Site Developement Plan Comments 2.pdf Markup Summary

[1] SDA-1 (2)

Subject: Planner
Page Label: [1] SDA-1
Author: Juhler
Date: 9/16/2026 9:42:49 AM
Status:
Color: ■
Layer:
Space:

SDA-1

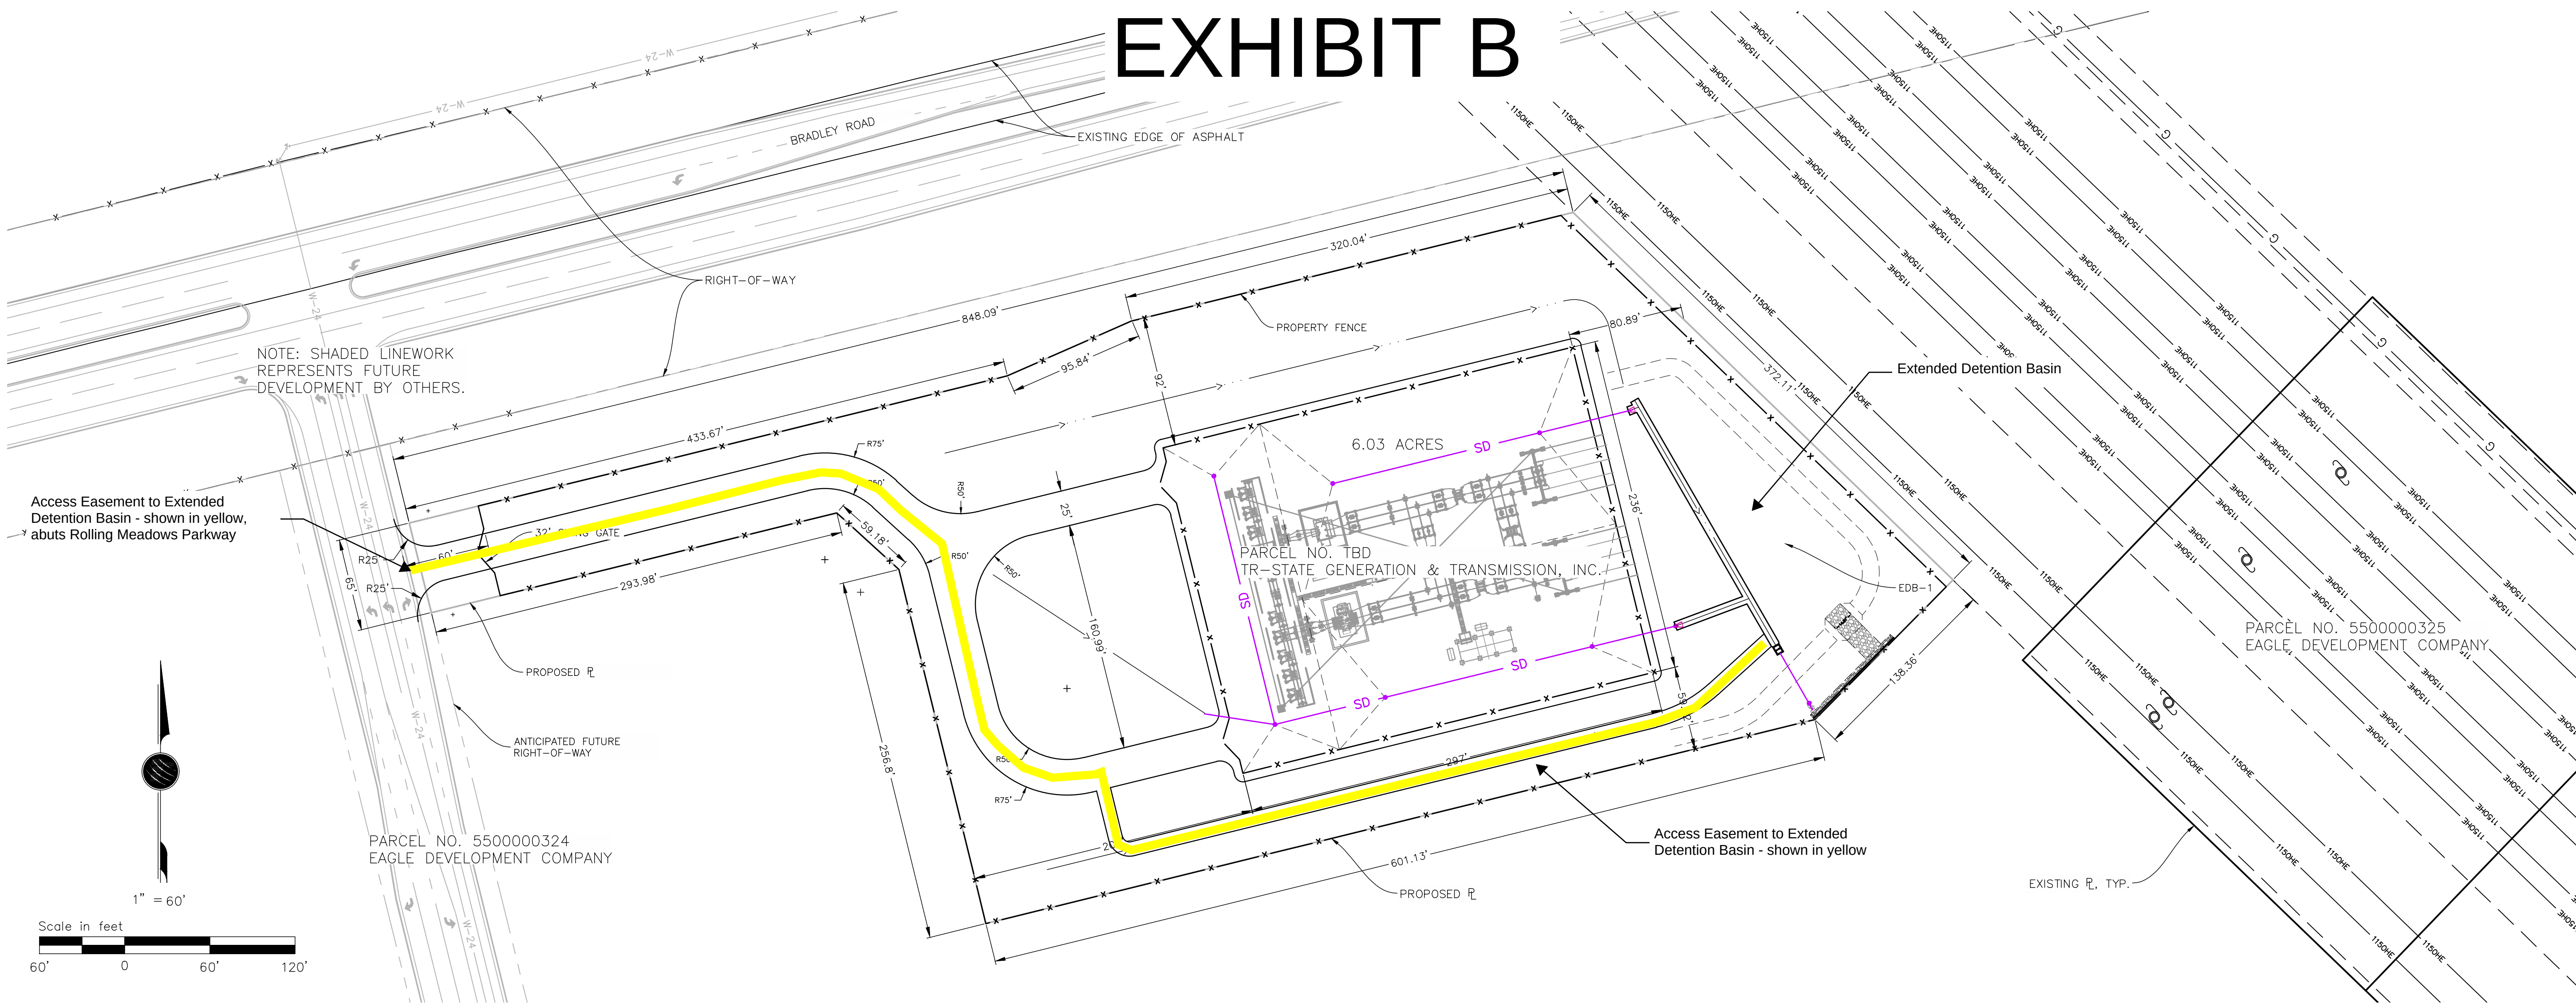
Is this fence line also the property line? Please label, if so.

Setbacks from property line need to be shown.

DMC RESPONSE: Yes, the fence line and property line overlap, additional labels have been added.

DMC RESPONSE: There are no setbacks for this tract. Dimensions from substation fence to property line are included. This was disucssed via email with J. Uhler on 09/16/26.
